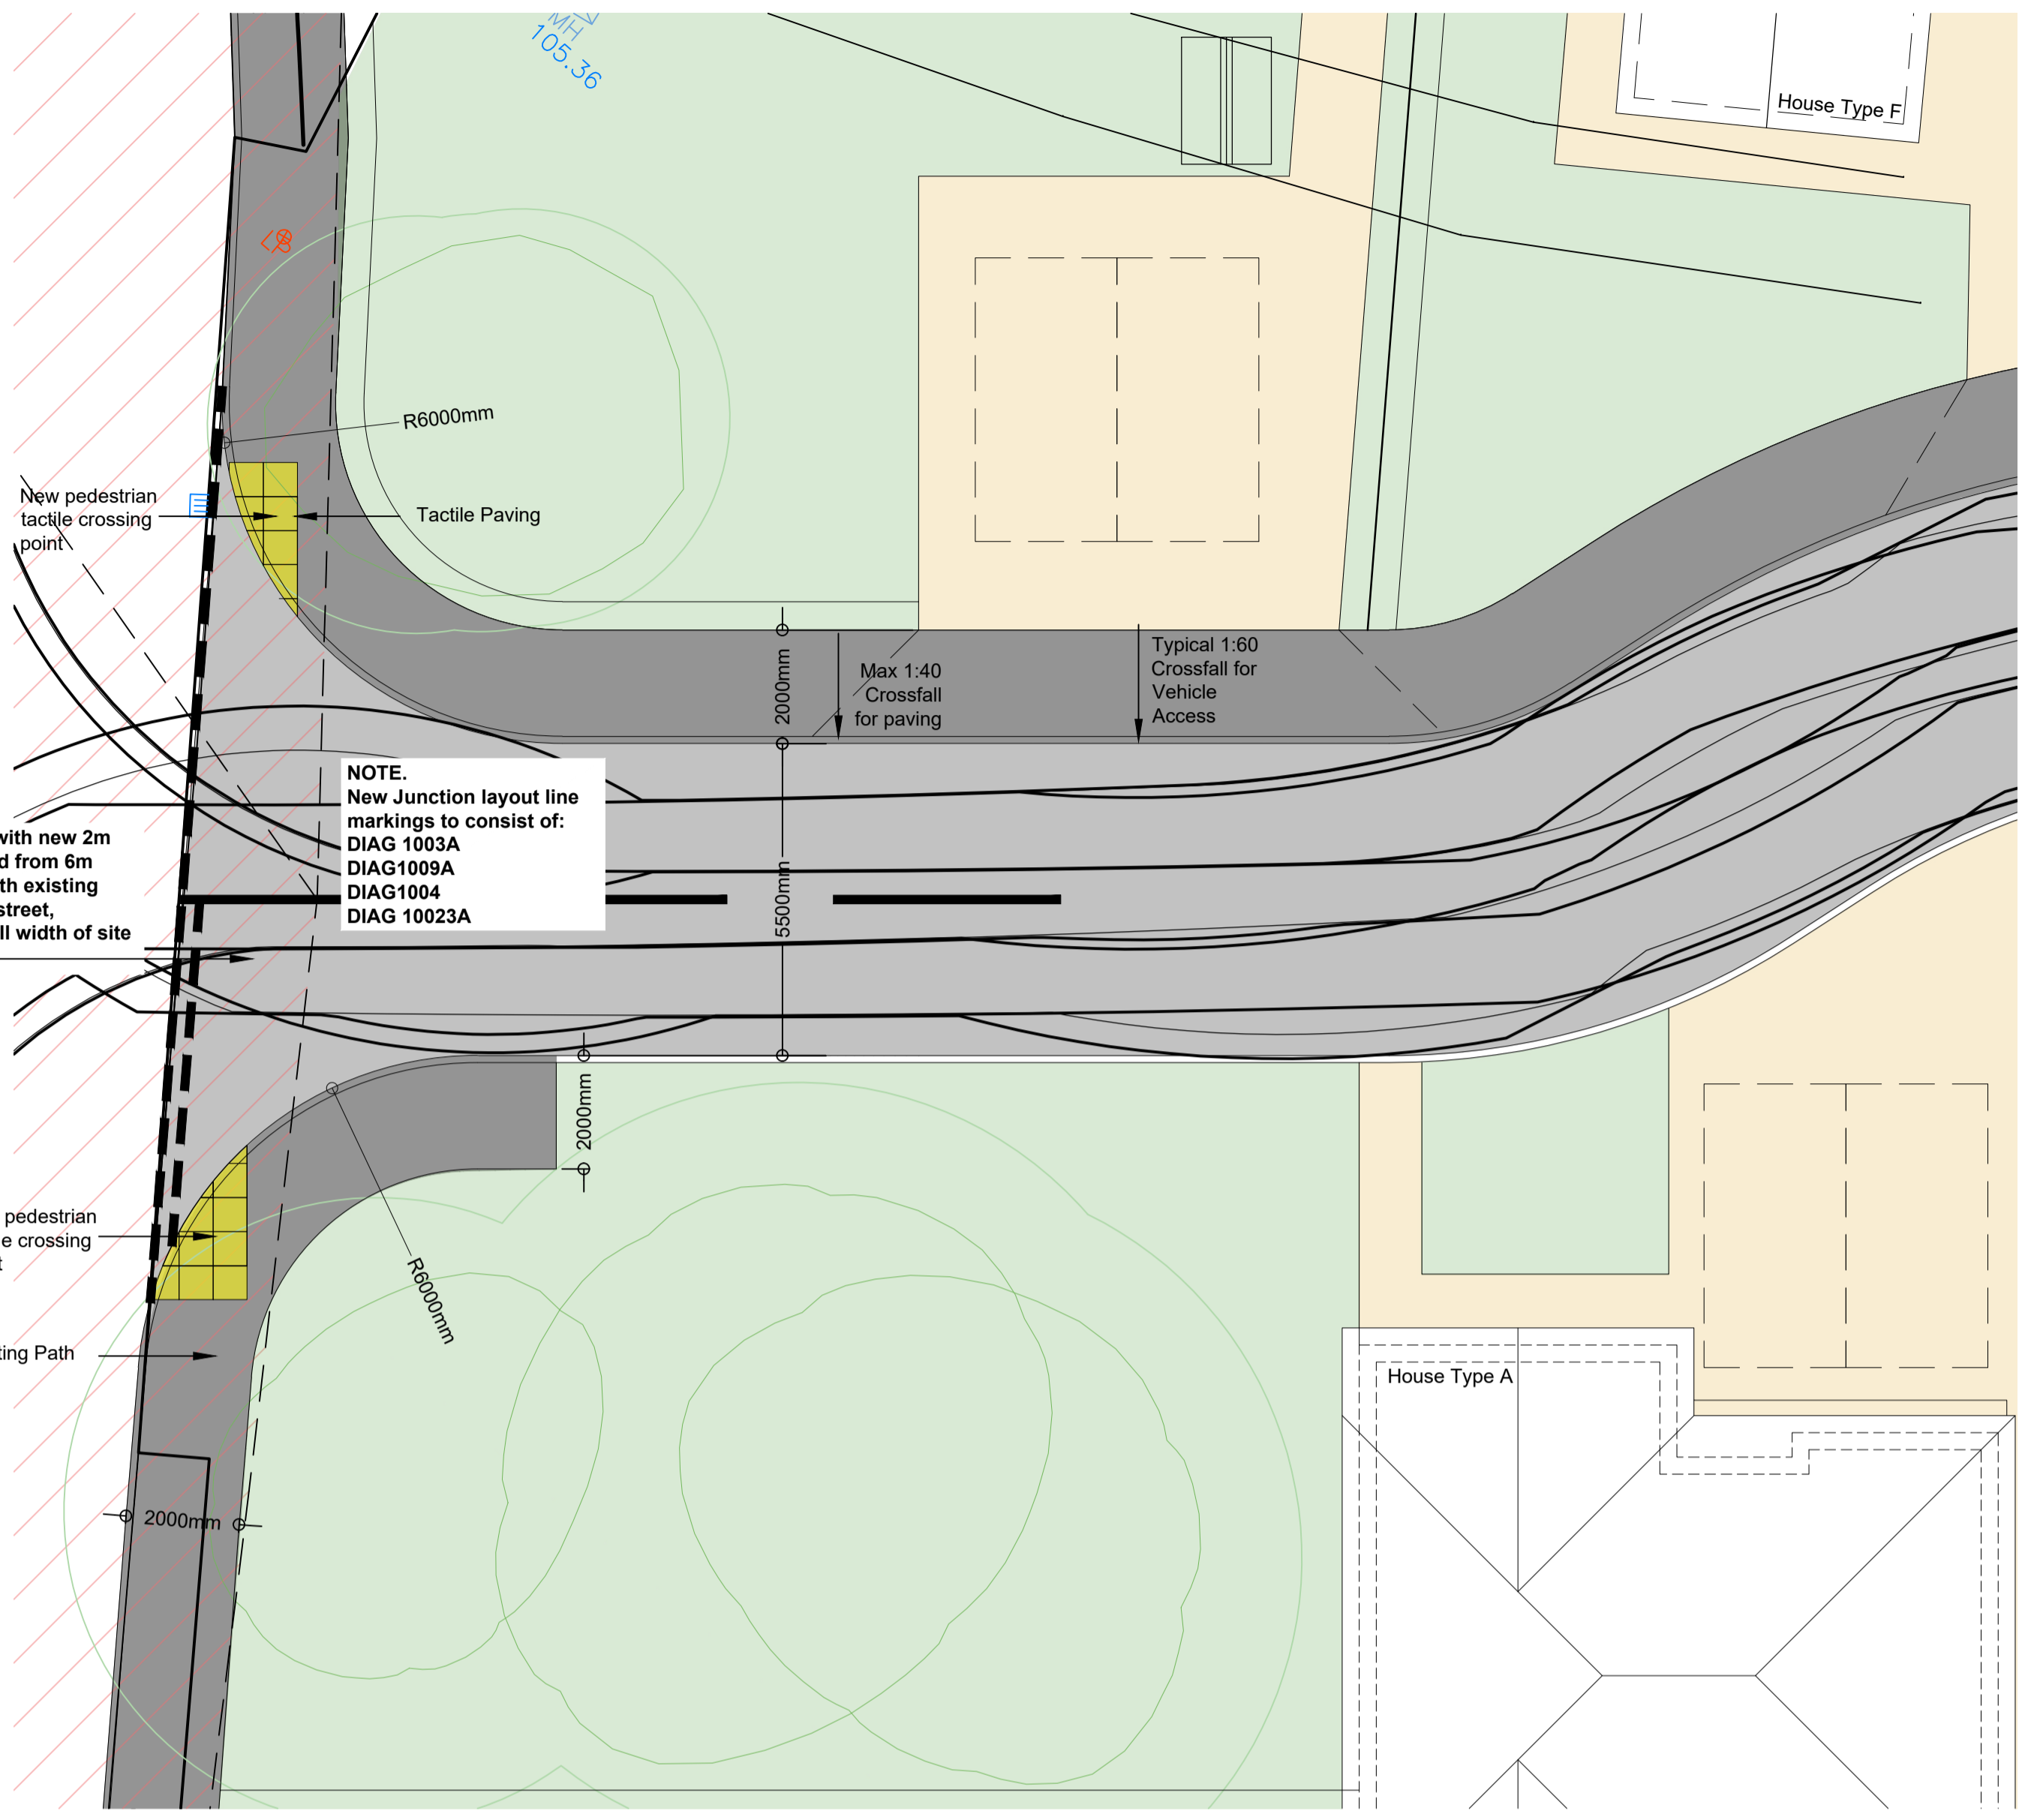
- Building for a Healthy Life Assessment required as per local validation checklist;
  - Please see attached requested assessment.
- Access appears overly wide but need to check with highway requirements;

**Highways DC** - Further information required, tracking for large refuse vehicles has not been provided. Amendments to layout required:

- No visitor parking proposed;
- A 2m distance between turning area and boundary treatments;
- Improved footways along site frontage;
- Compliance with Stage 1 Road Safety Audit;

- Query regarding possible further development;
  - No discussion has been had with the Client or Local authority in relation to a further development. The road leads up to the boundary to achieve the require turning head for Large refuse vehicles as requested by Highways. Additional planting and the removal of the path and 1.8mm fence has been implements to soften the boundary.

- Access is to comply with splays, refuse vehicle turning circle and to achieve safer egress into the site, no comments from highways has been put forward in relation to the width of this access.

Requested Information has now been provided
